Rezoning Transportation Analysis

Petition Number: 2021-089

Revision Log:

Date	Description
08-20-2021	First Review (WB)
10-15-2021	Second Review (AO)

SHEET NUMBER:  
**RZ1.0**

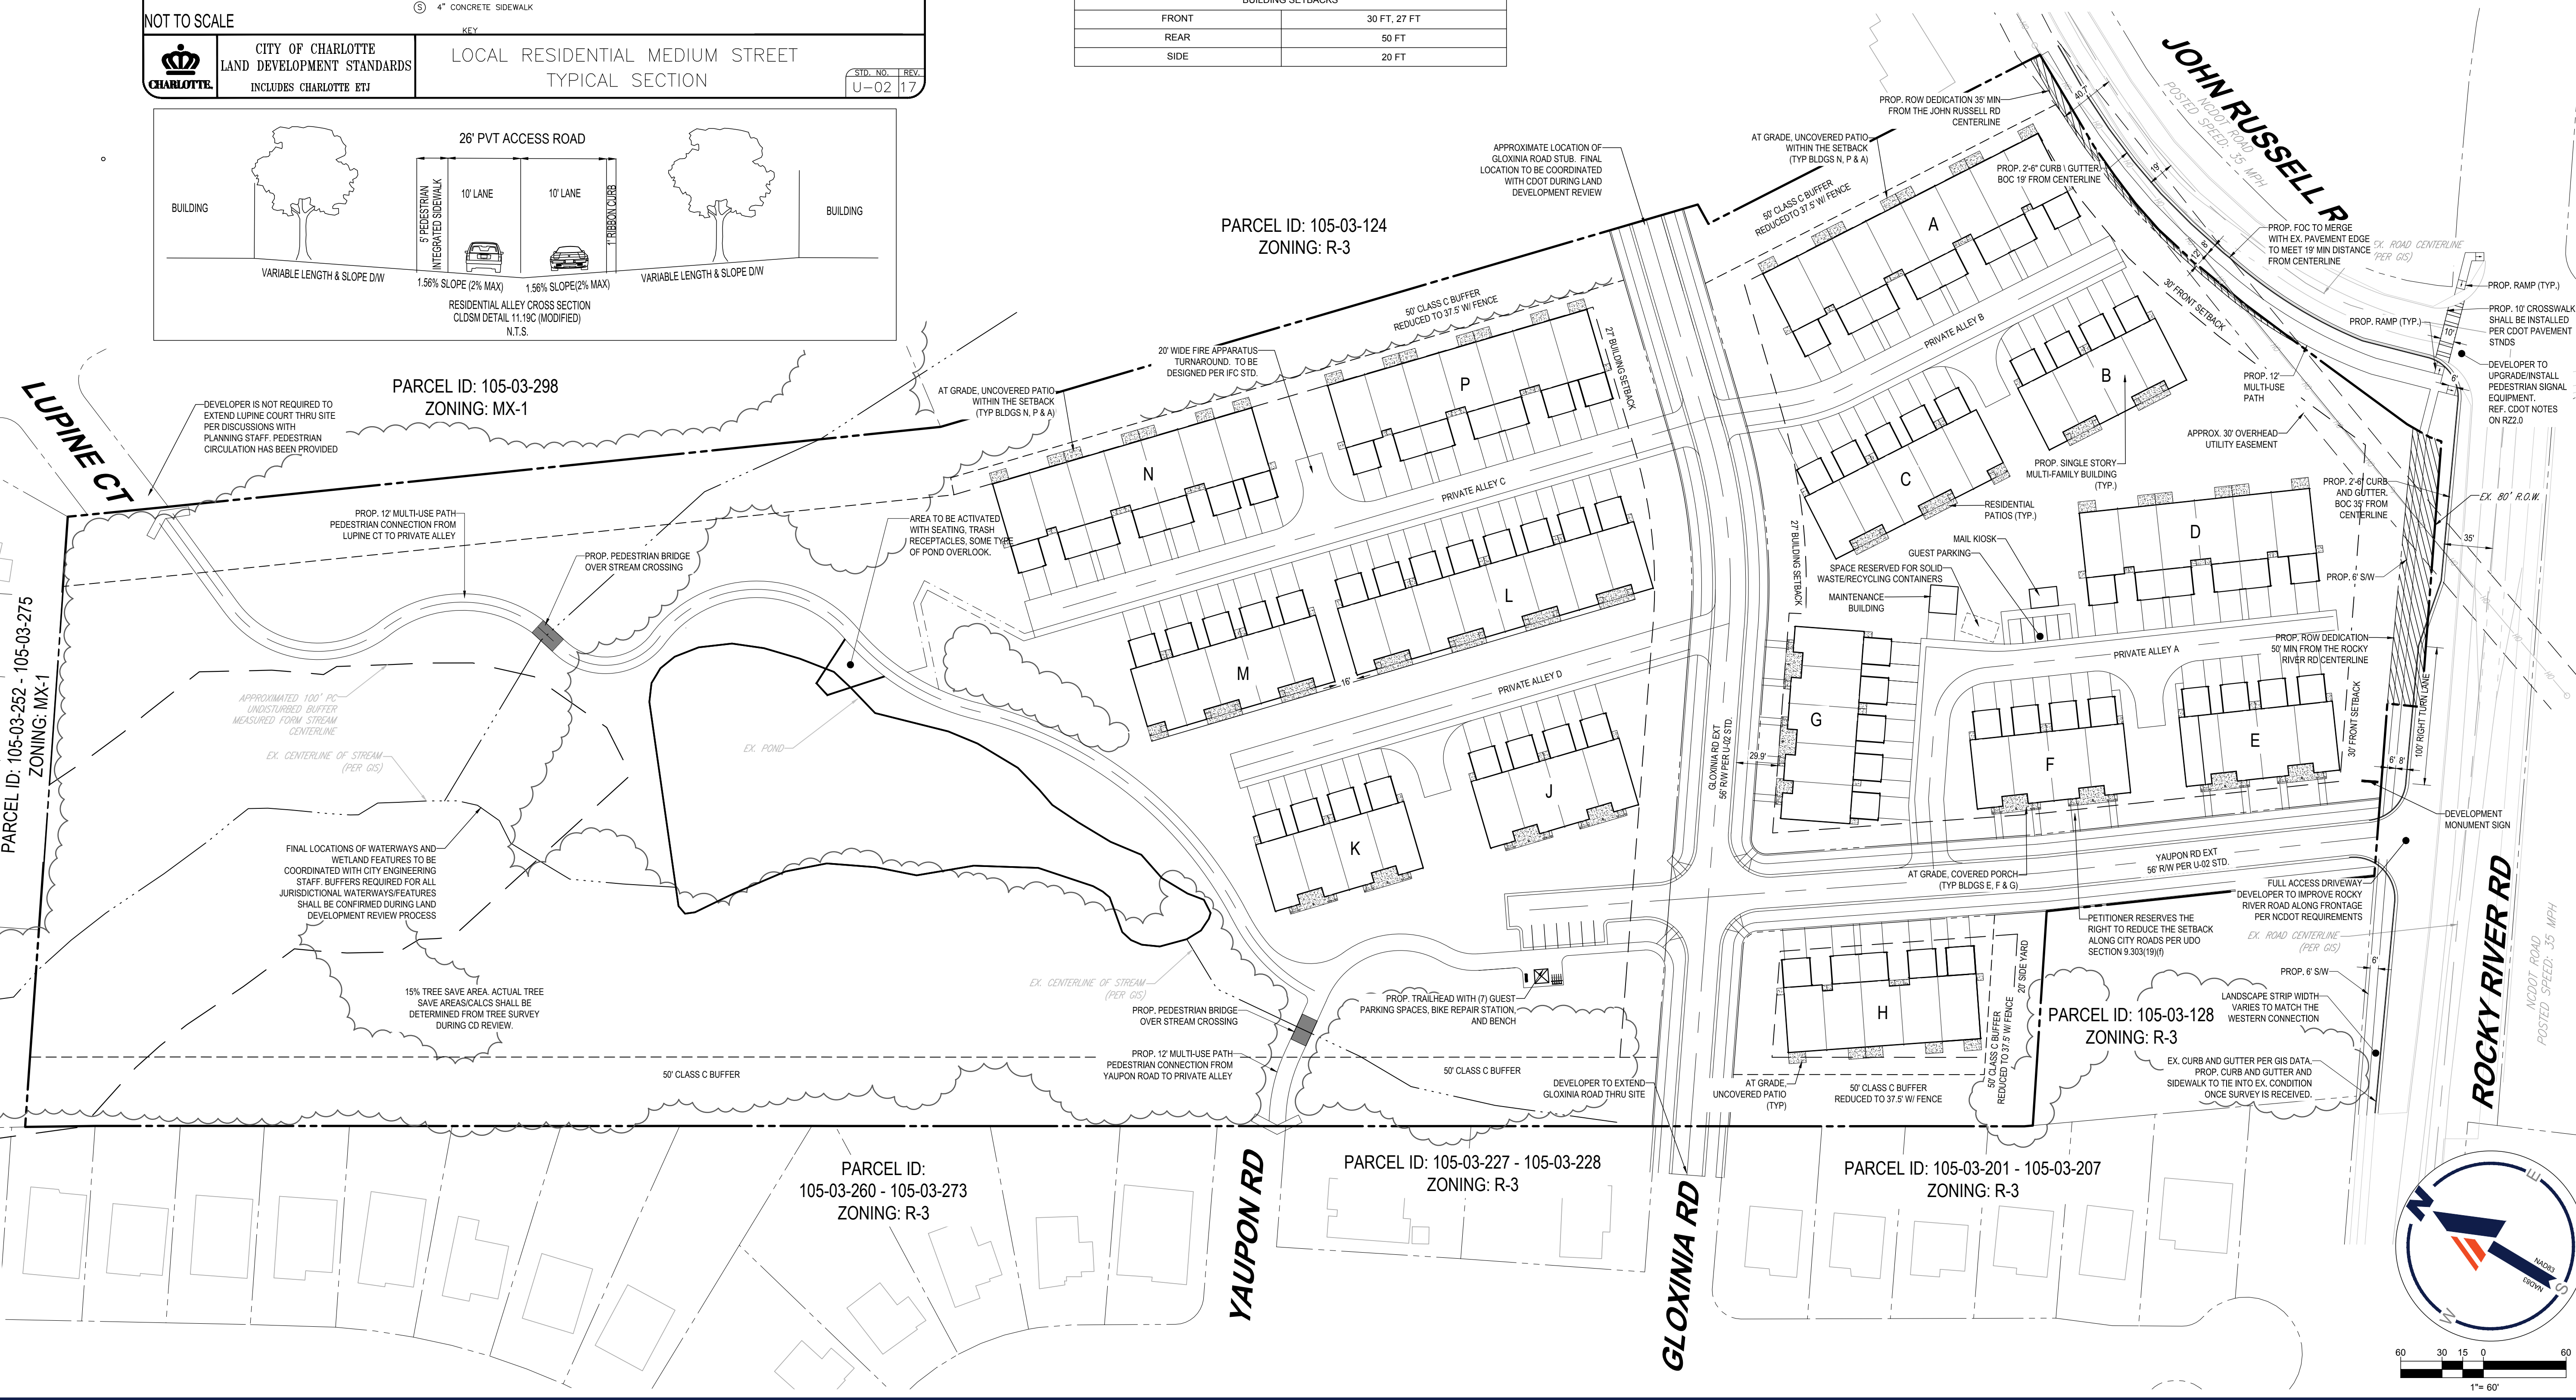
8. Revise site plan and conditional note(s) to commit to construct accessible ramps and a crosswalk at the John Russel Road Intersection to provide accessibility in accordance with PROWAG and ADA. The site plan shall label and dimension all items.

Technical Clarification (10-18-21): The crosswalk width to be 10' wide unless otherwise specified.
